Re. Walmart #5491.245 located at: 2266 Wyoming Blvd NE

The scope of work for this Administrative Amendment review is for updating this review for the current Walmart #5491.245 main building/site signage to the new updated font and new branding signage. This work was previously approved in the attach AA; however, this project did not start and was pushed to this date. The OGP parking will also relocate as shown on the civil sheets.

SITE
SIGNAGE
PLAN

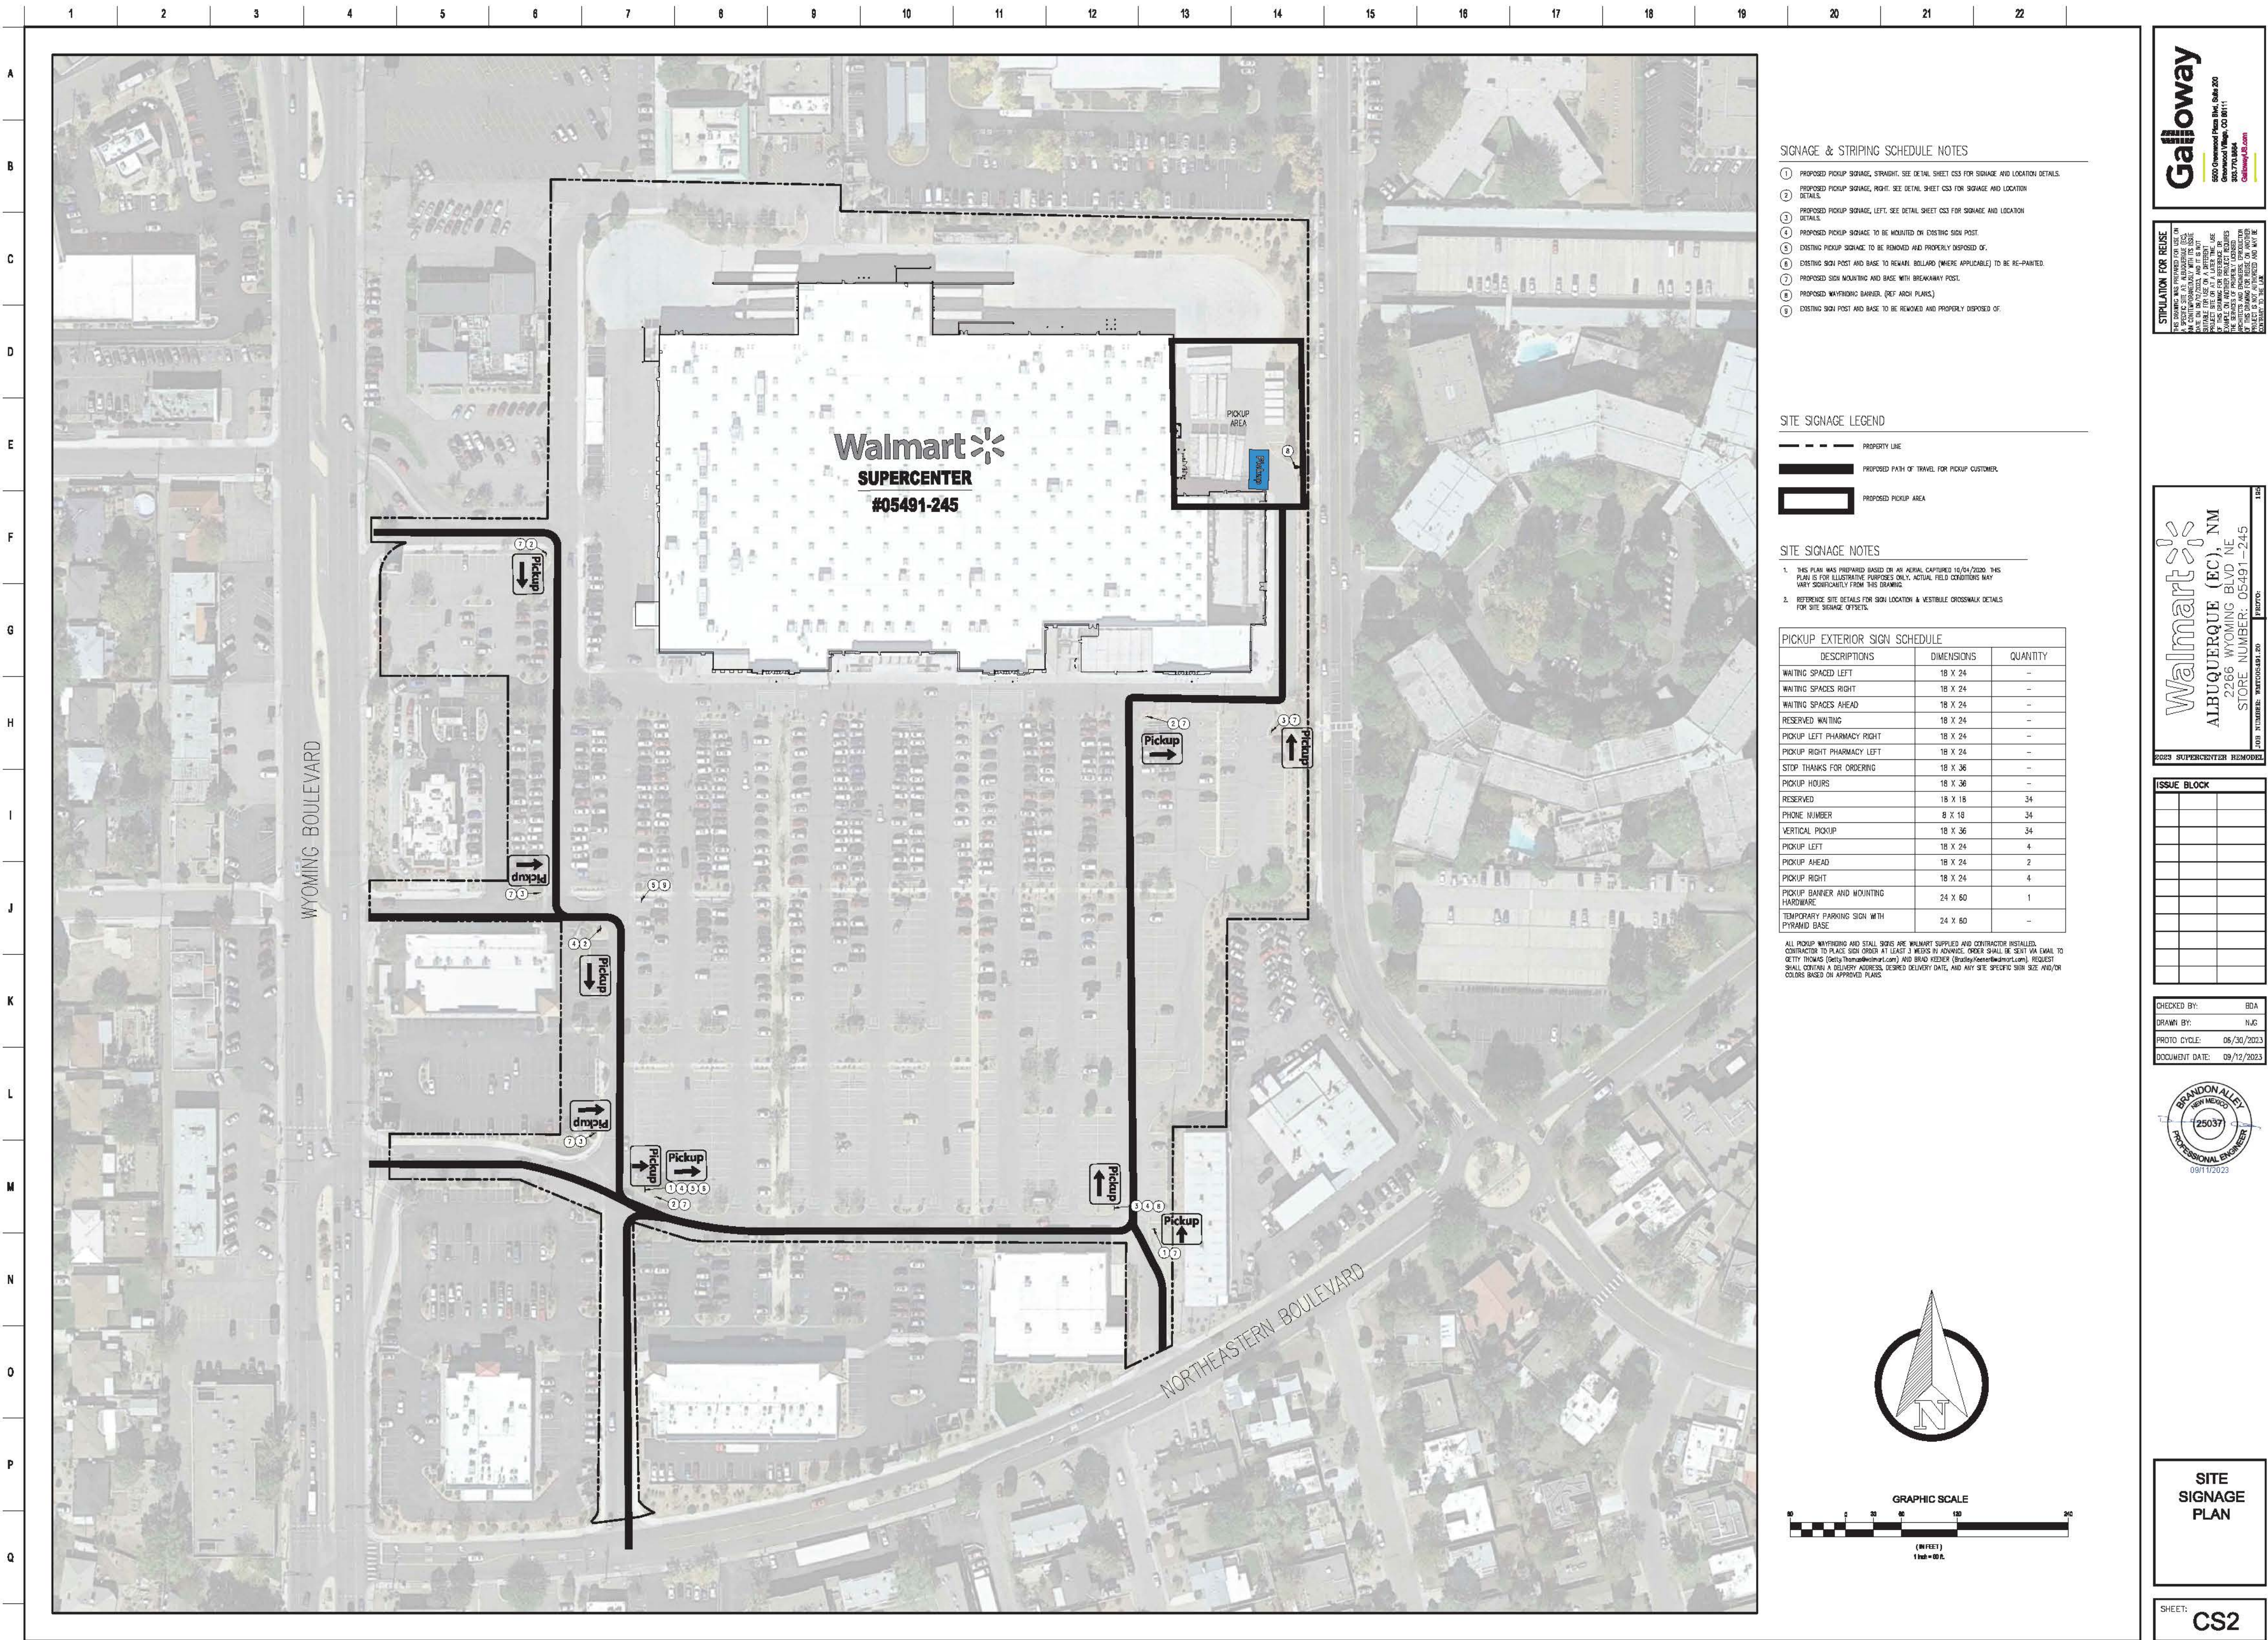
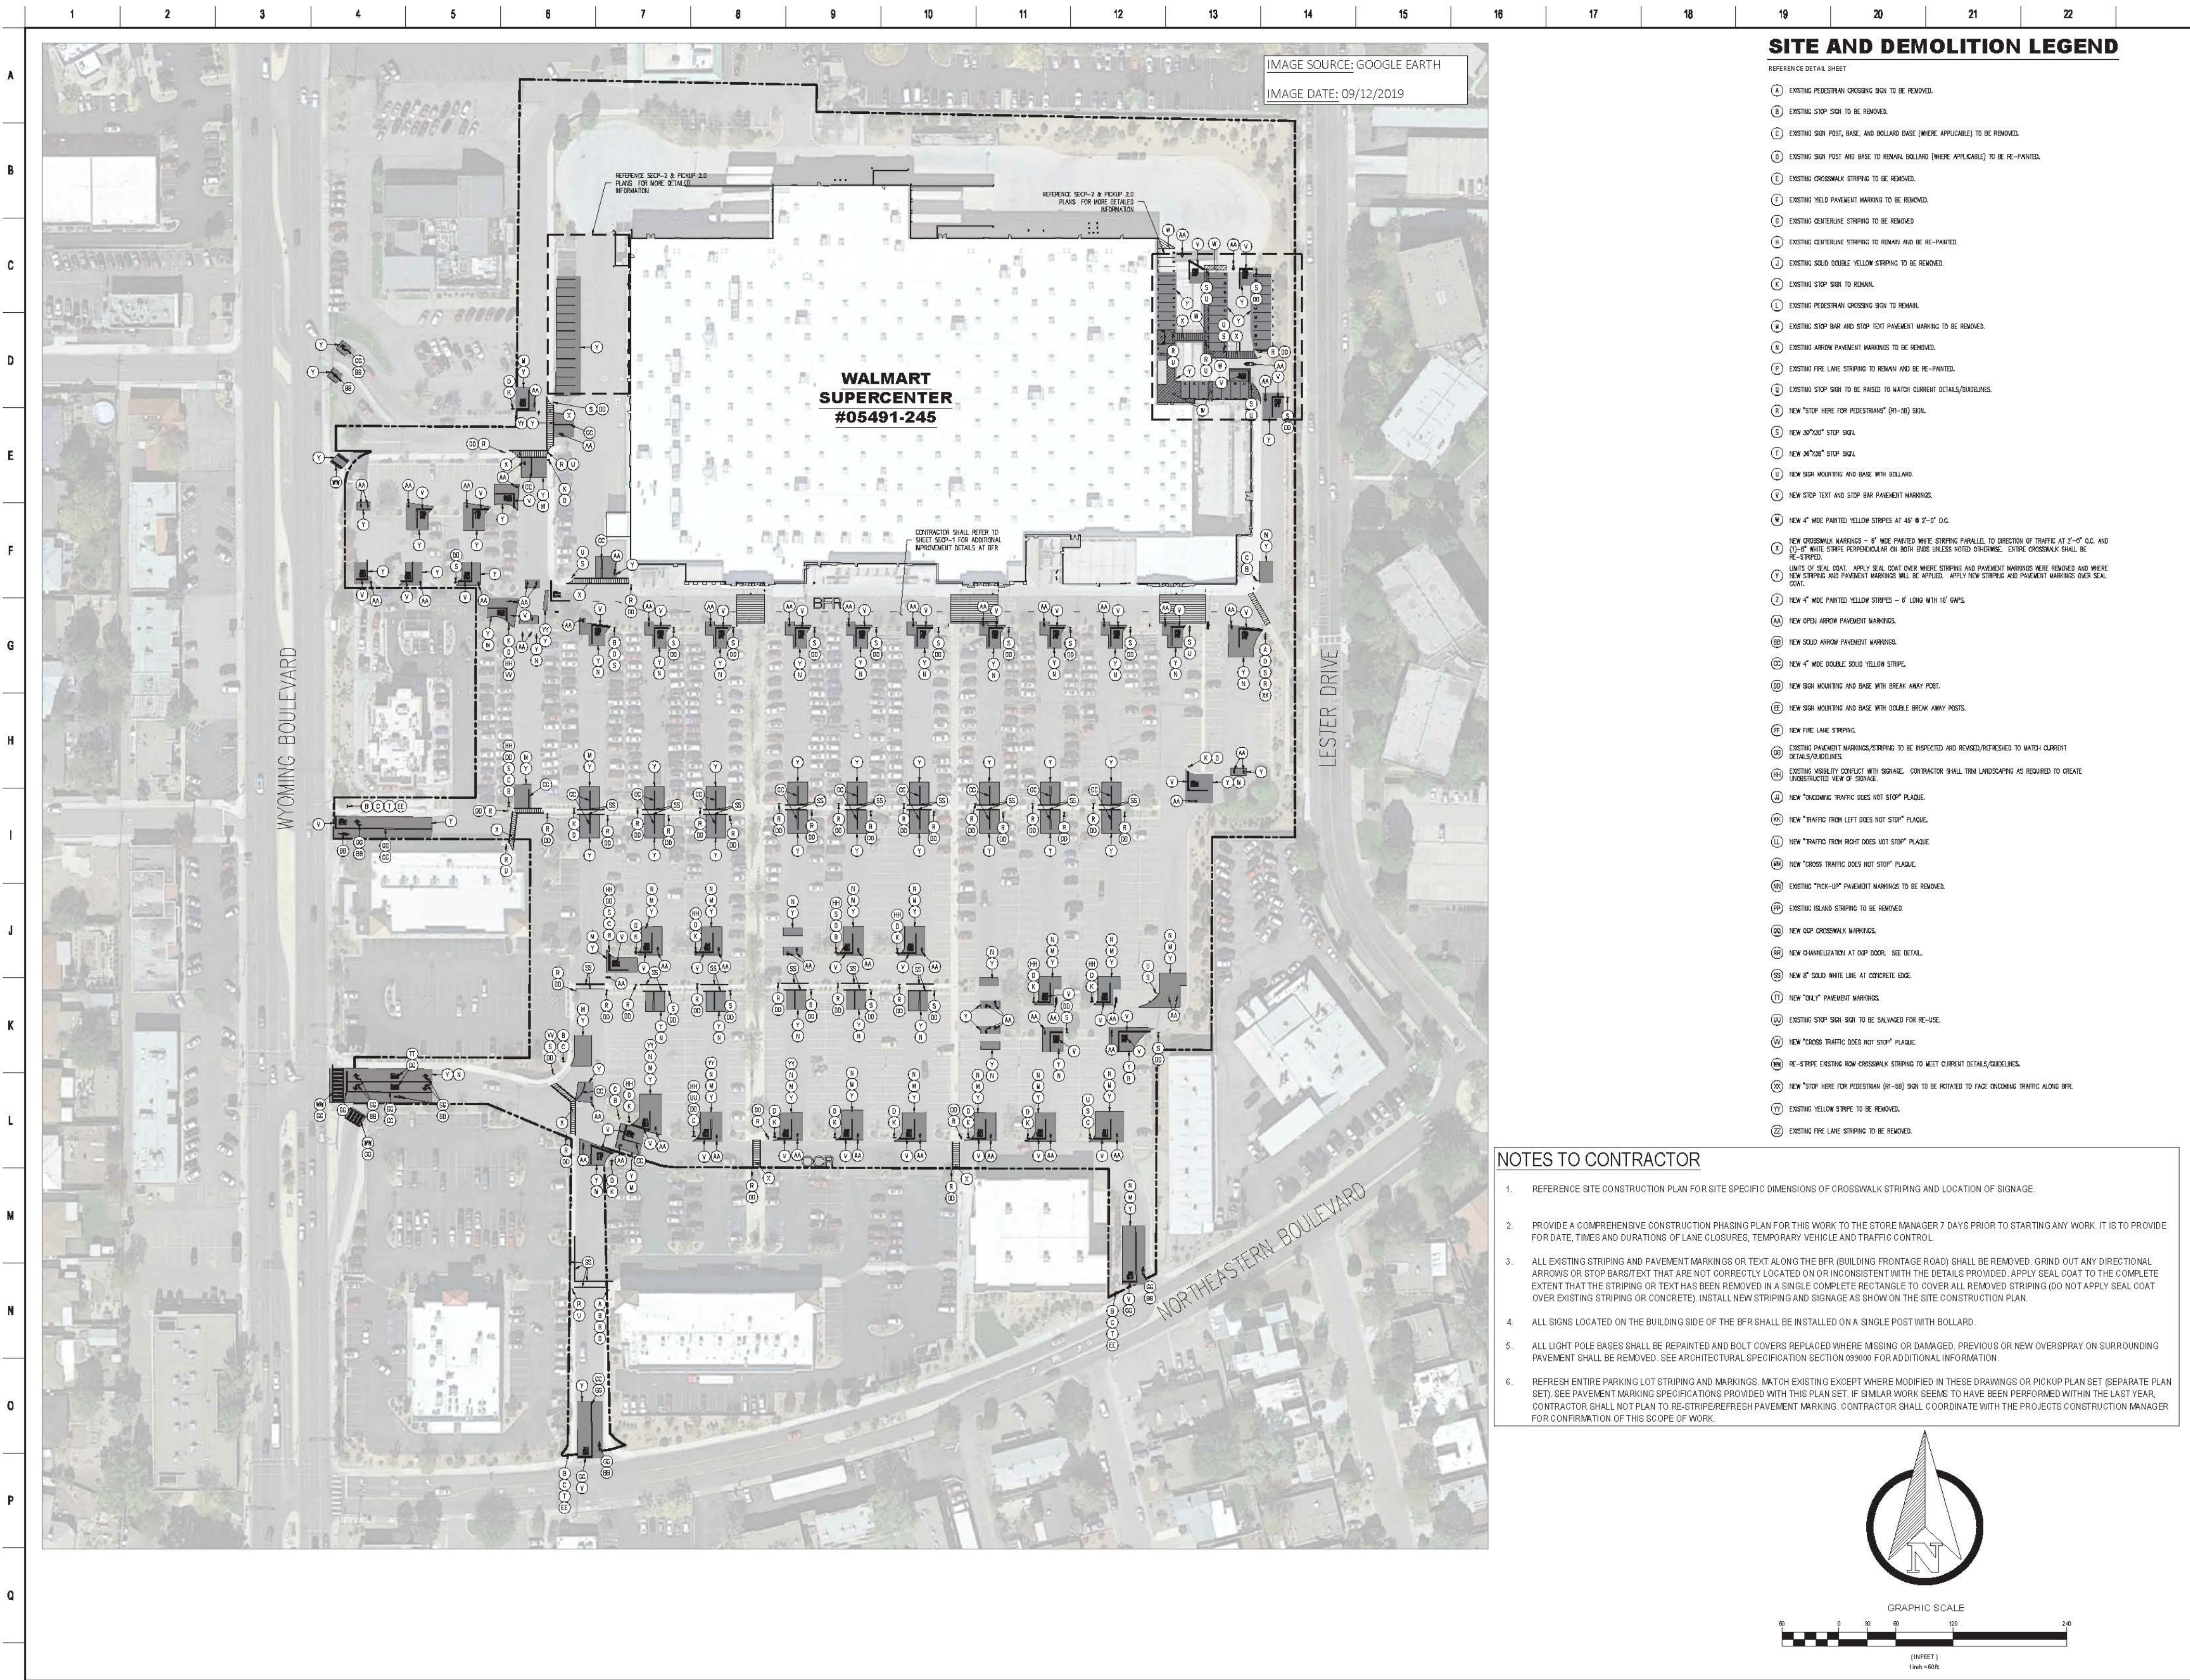
Regarding the signage updates, the main Walmart w/ Spark Sign will be updated. The rest of the wall signage will change out like for like. The Site signage will change orange to blue also. The designated OGP parking will be expanded with additional spaces single lined spaces. The pharmacy drive-thru has relocated to the side.

Bollards will be updated to have consistent spacing and change to gray brand color.
